# WATERVIEW EAST - COMMERCIAL SITE ADDITION ZONING MAP

LOCATED IN A PORTION OF SECTION 9, T15S, R65W OF THE 6TH P.M.,  
EL PASO COUNTY, STATE OF COLORADO

WATERVIEW EAST - COMMERCIAL ADDITION ZONING MAP		
Designer: BG	Structure Numbers	Project No./Code 181710214 CS-18-002 Sheet Number 1 of 1
Detailer: BG		
Sheet Subset:

WATERVIEW EAST - COMMERCIAL ADDITION ZONING MAP

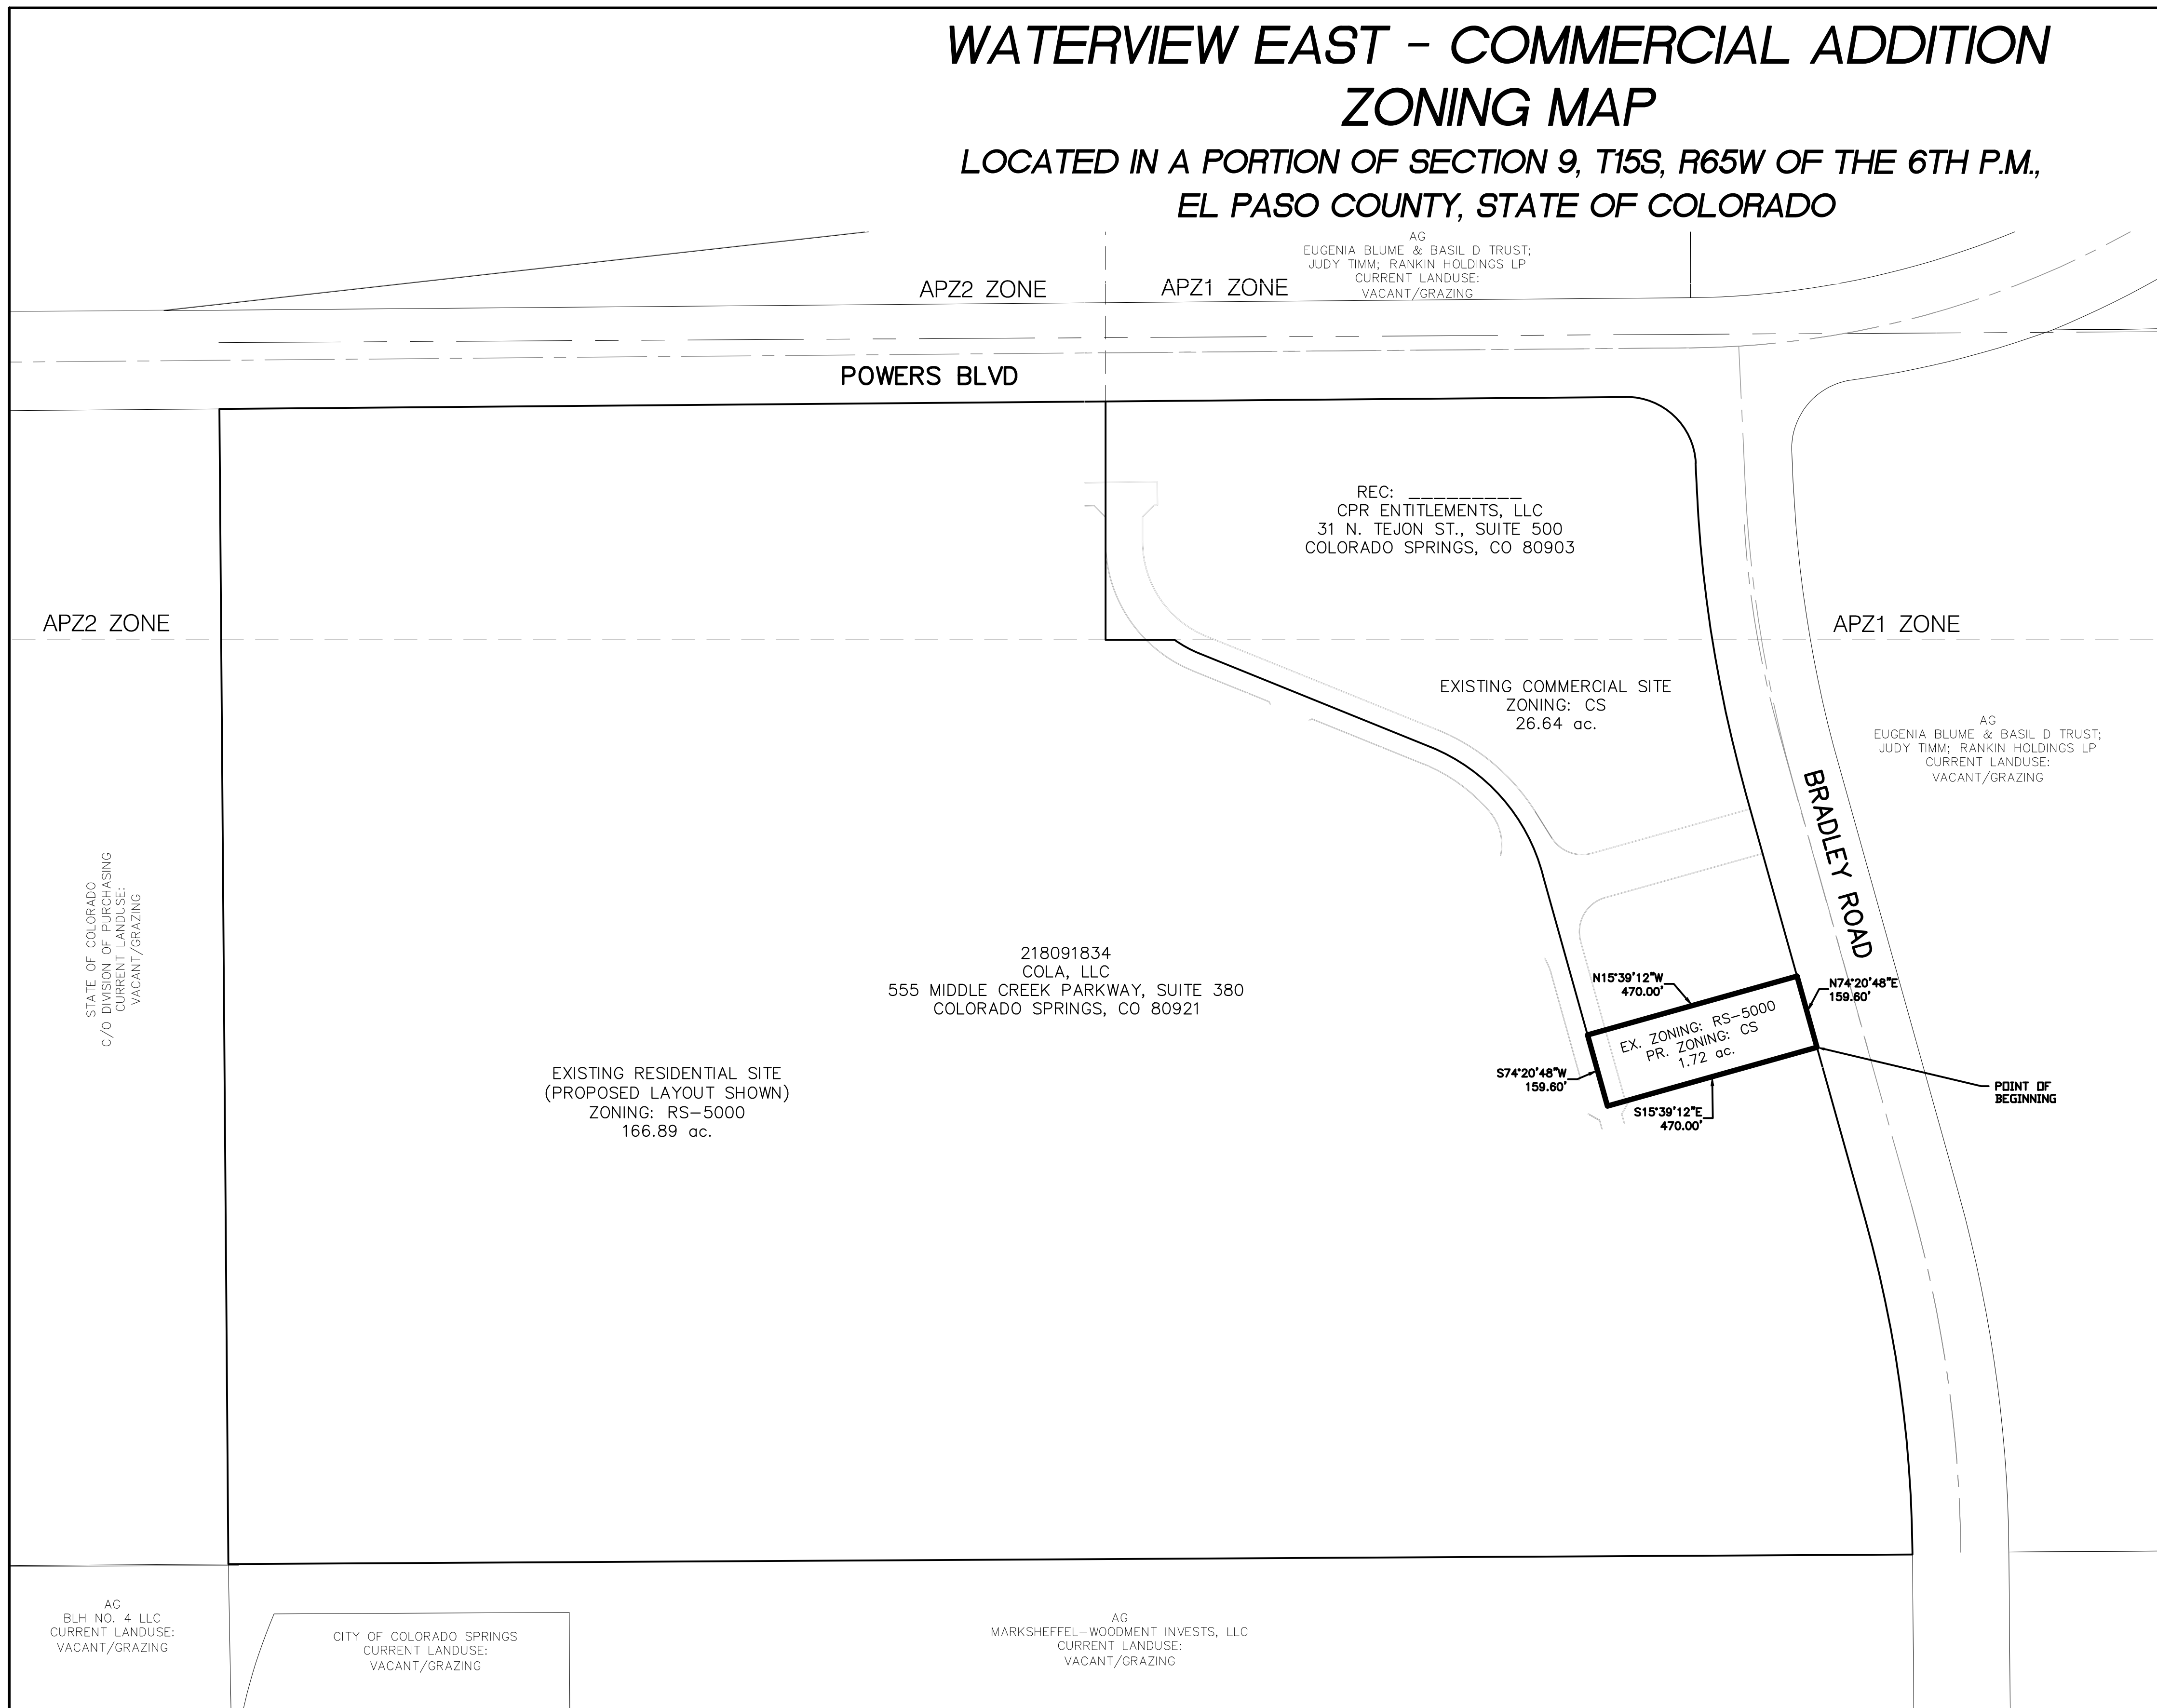
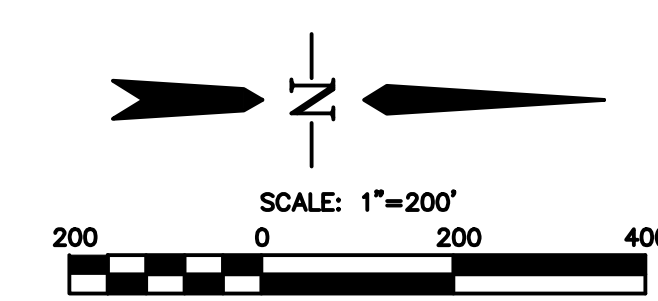
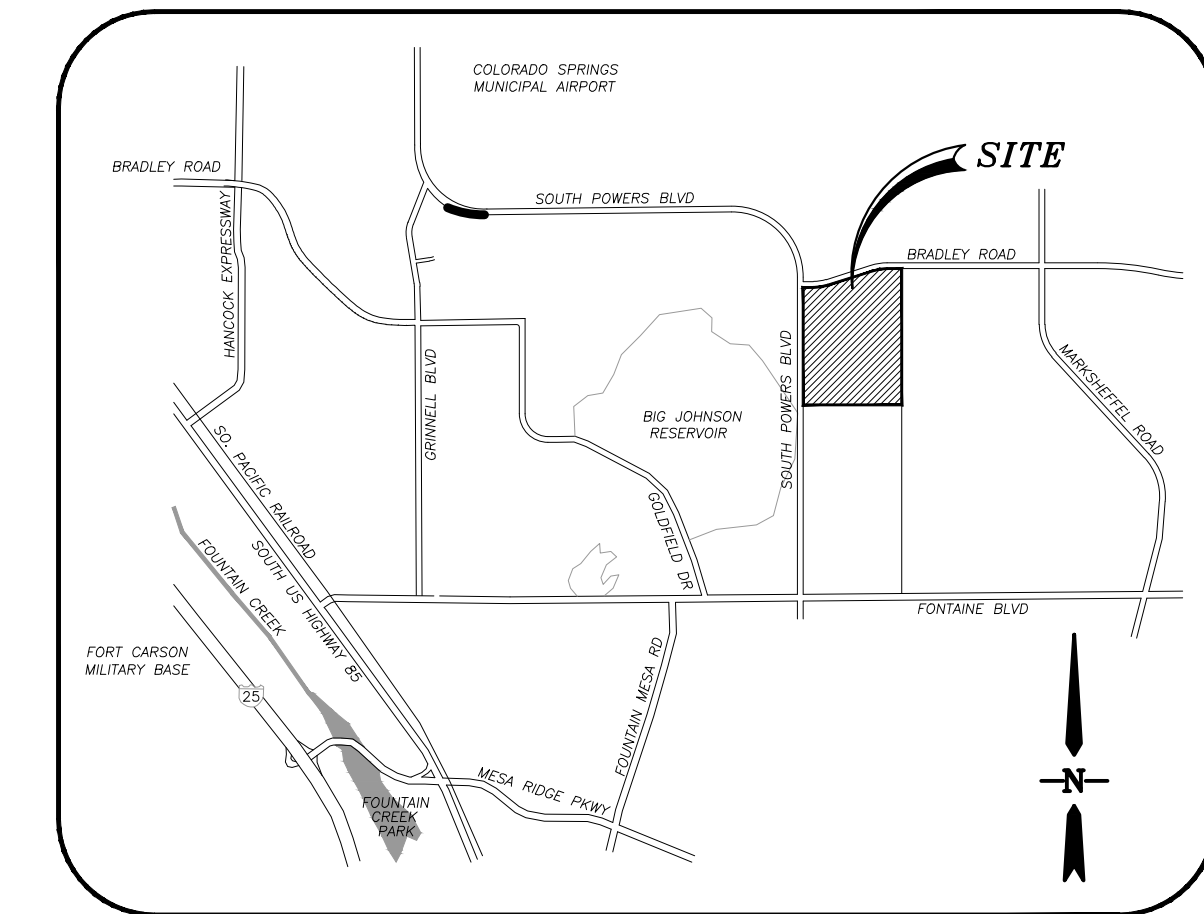
Please make it clear that this is the layout that is being requested but not yet approved.

please make it clear this is the area being requested for rezone. Please also update the access shown to follow the amended request.

please reverse the E and W
